Departure Reference:	N017	Departure Type:	General
Document File Name:	133735_RW-EWR-XX-XX-RP-CH-000149	Local Highway Authority:	Oxfordshire County Council

Departure Title:	Reduced visibility standard along the major road at Compound Access A2 (Station Road)
Departure Location:	
Supporting Information:	<p>General Arrangement Drawings Number Compound A2 - 133735_2A-EWR-OXD-CC_A2-DR-CH-002001</p> <p>Visibility Splay Drawings Number Compound A2 - 133735_2A-EWR-OXD-CC_A2-DR-CH-002012</p>
Consultations:	Oxfordshire County Council

Departure Description:	Visibility from minor arm along major road is sub-standard.
Associated Departures:	None
Reason for Departure:	The junctions listed above do not appear to provide the required visibility distance 'y' from the junction along the major road, for their respective posted speed limits.

- VISIBILITY SPLAY
- HIGHWAY BOUNDARY
- PROPOSED ROAD EDGE

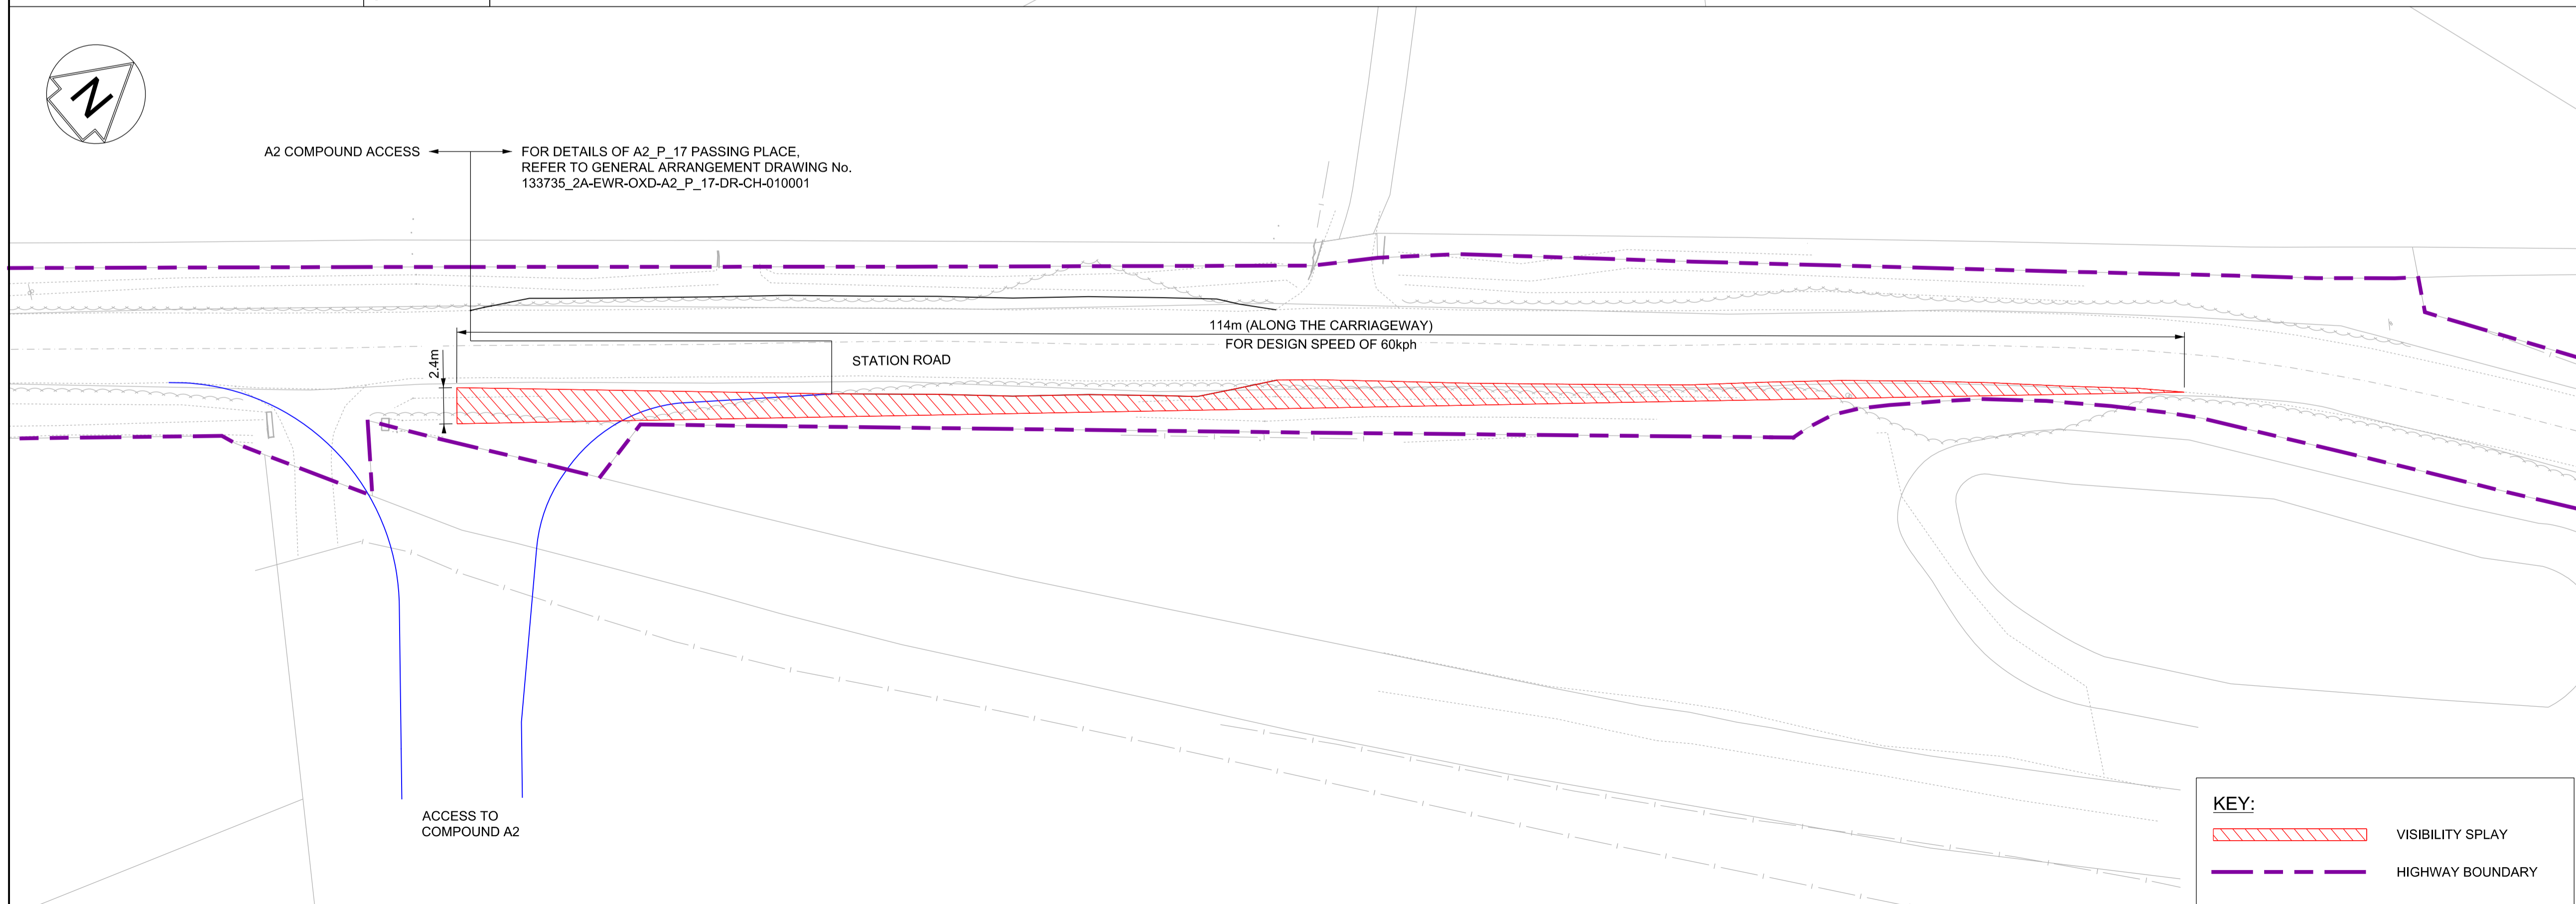
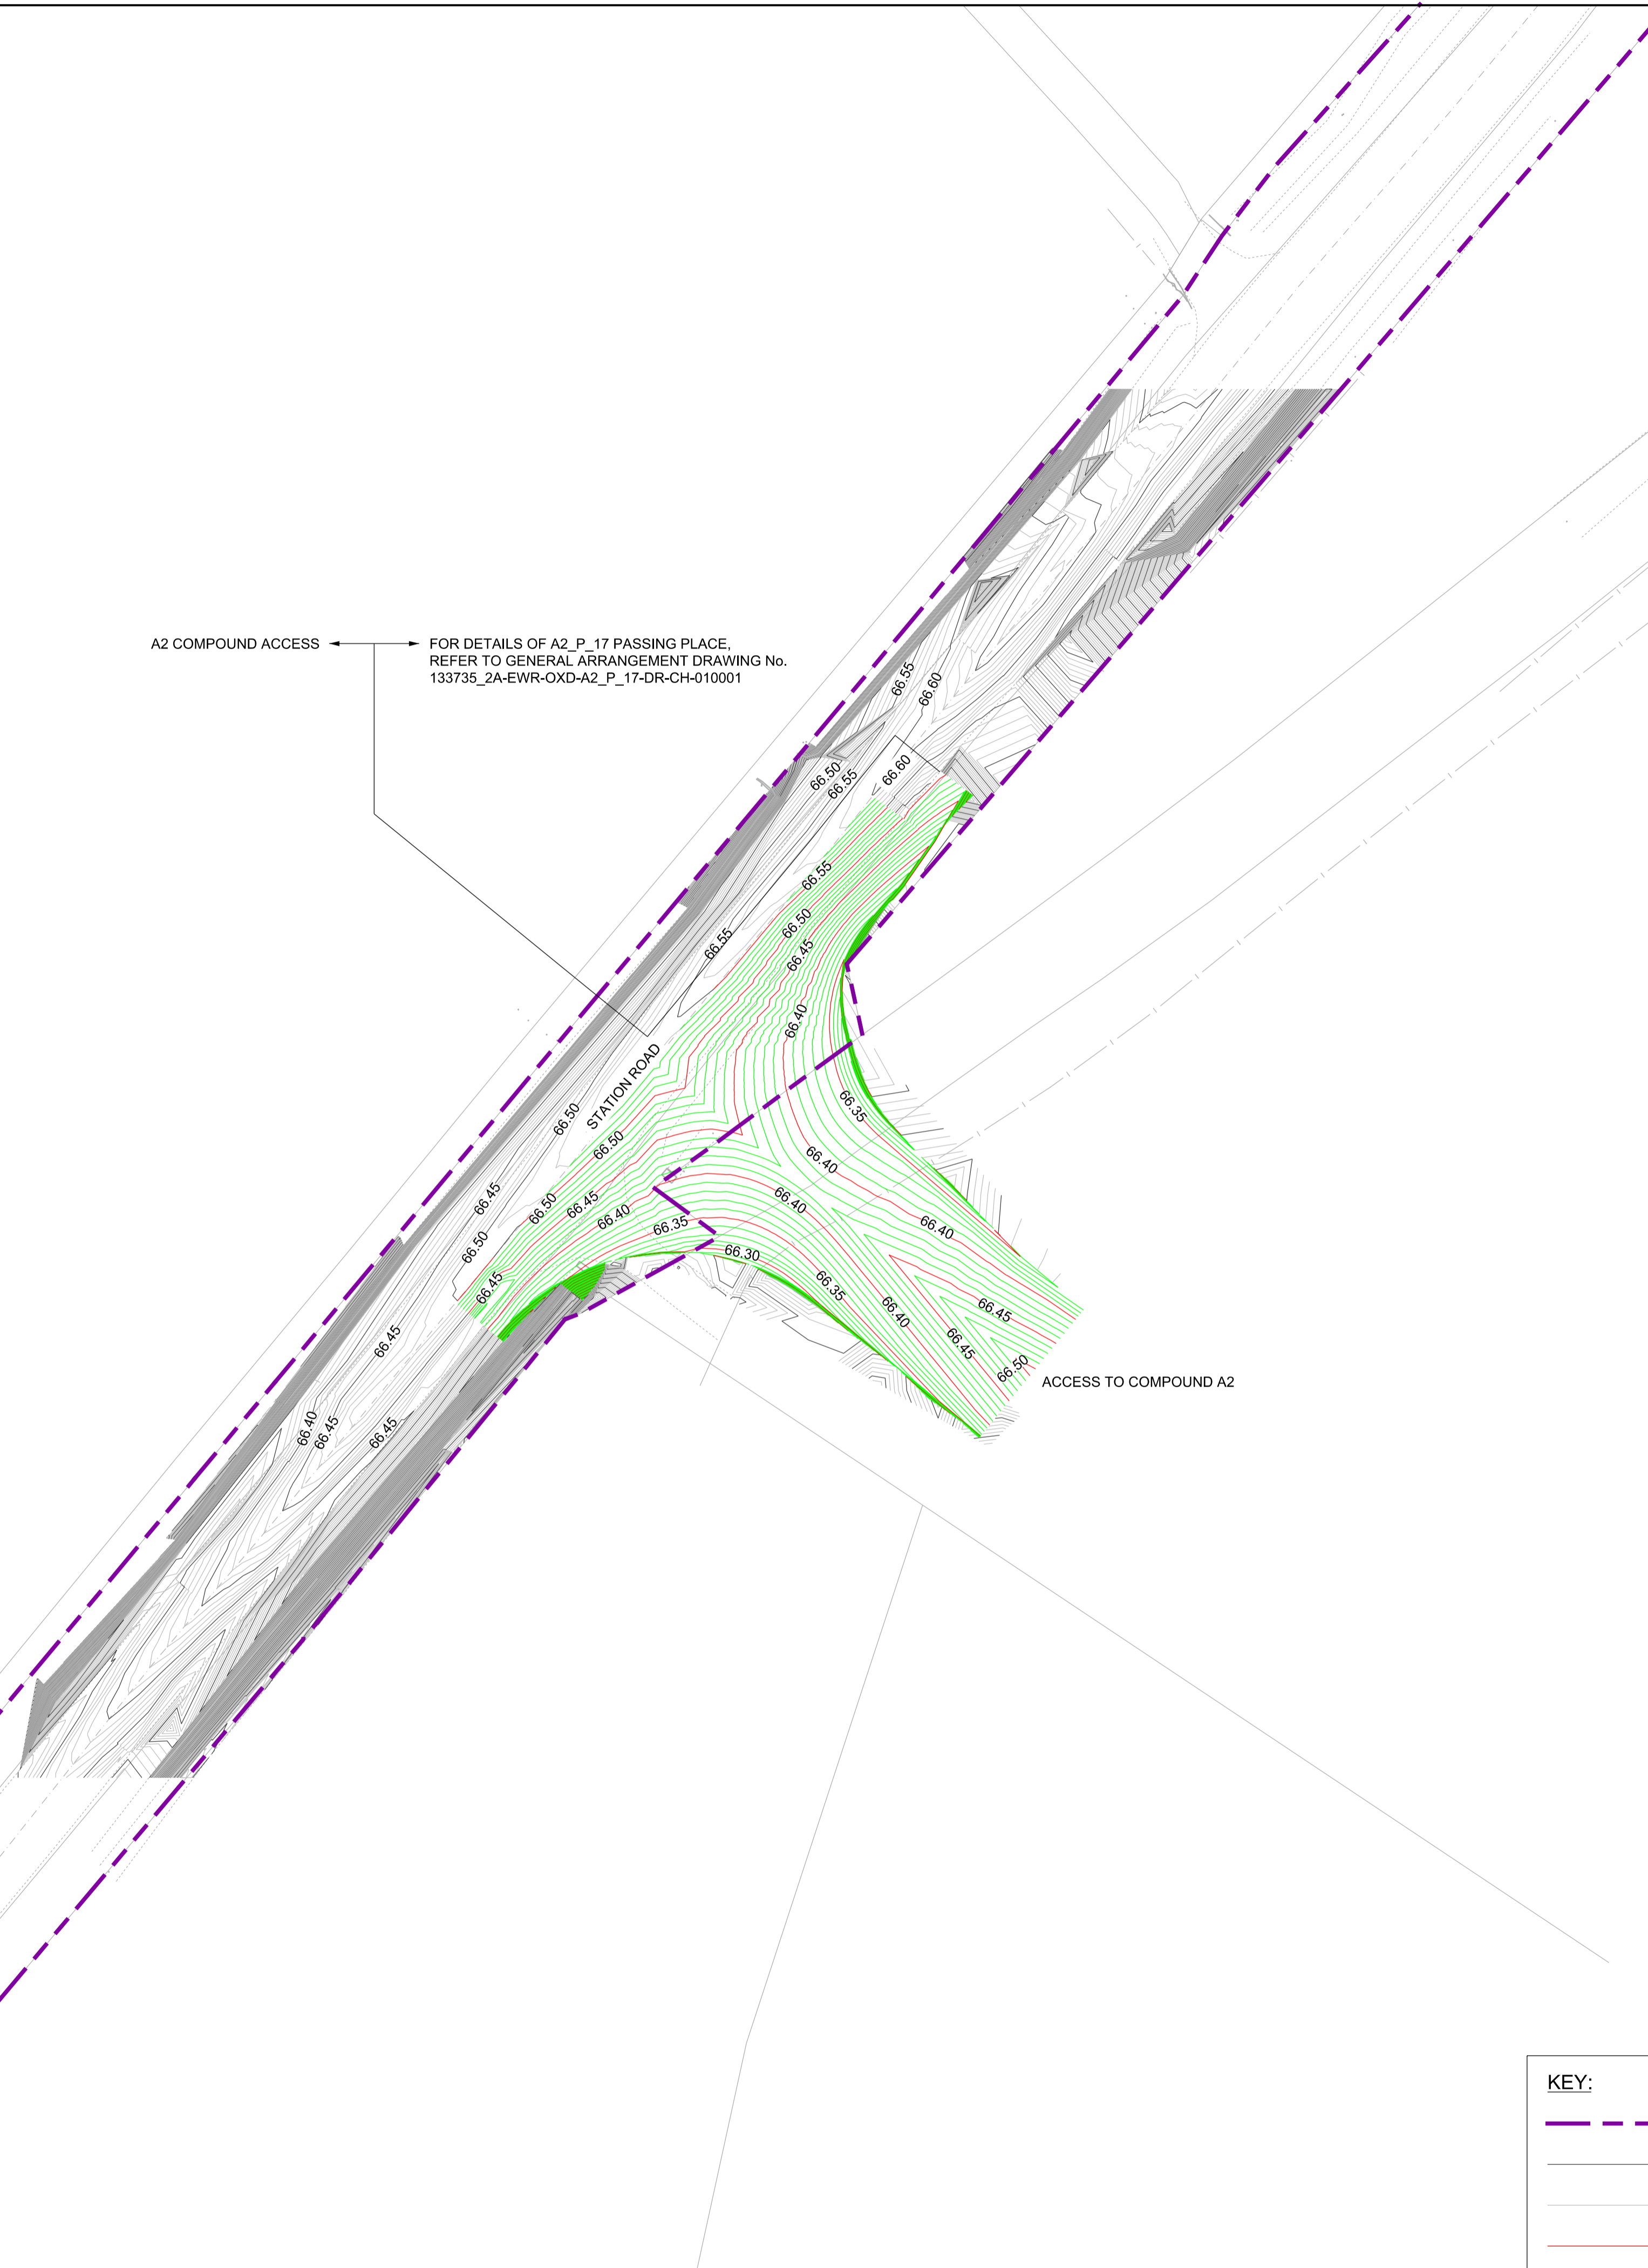
Location	'y' Distance			'x' Distance Achieved (m)
	Specified (m)	Achieved (m)		
		Existing	Proposed	
Comp. A2 Right	160	14	114	2.4
Comp. A2 Left	160	7	123	2.4

Visibility has been maximised as far as reasonably practicable without having an adverse impact on the mature vegetation. The constraints are beyond the control of EWR Alliance and it is not possible to amend the constraints or move the access locations, due to requirements for maintenance and construction of EWR. The A2 compound access is temporary and will be removed when construction of EWR is complete. Vehicles using the junction will be under

The design for the A2 compound access widens an existing field access which currently has visibility that is substantially below the required 160m and as such the proposed works will improve this significantly.

Risk Assessment Classification:	n/a
Other Options Considered:	n/a
Mitigation:	To ensure the 'y' distances stated are achieved regular vegetation trimming will take place along the verge for the duration of the construction period. Station Road to the north of the compound access will be closed to allow the construction of the realigned section and associated overbridge.
